STATUTORY PLANNING CONSULTATION RESPONSE

Application Number:	3/2026/0314
Proposal:	Approval of details reserved by condition 18 (Travel plan), condition 19 (Construction Management Plan), condition 23 (Surface Water Drainage Scheme) and condition 25 (Construction Environmental Management Plan) on planning permission 3/2020/0601.
Location:	Land at Highmoor Farm Clitheroe BB7 1PN

The Lead Local Flood Authority **recommends the discharge of condition 23** on planning decision 3/2020/0601.

Client: MORRIS HOMES  
 Project: HIGHMOOR FARM, CLITHEROE  
 Title: Drainage Strategy Layout - Masterplan

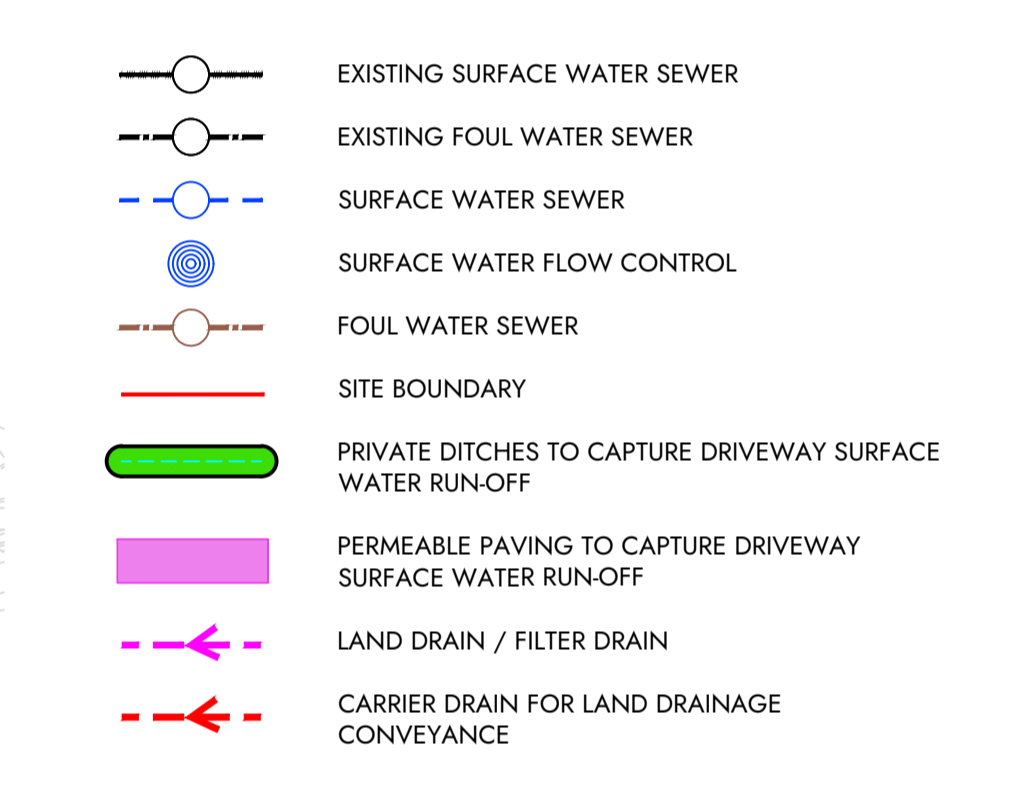
- The applicant should take note that the drainage layout plan shows that manhole S16 shows a cover level higher than that of the finished floor level of the adjacent houses, which could pose a risk in a flooding event, it is not clear from the provided evidence if this risk has been mitigated against through the camber of the road or the slope of the driveway being away from the house.
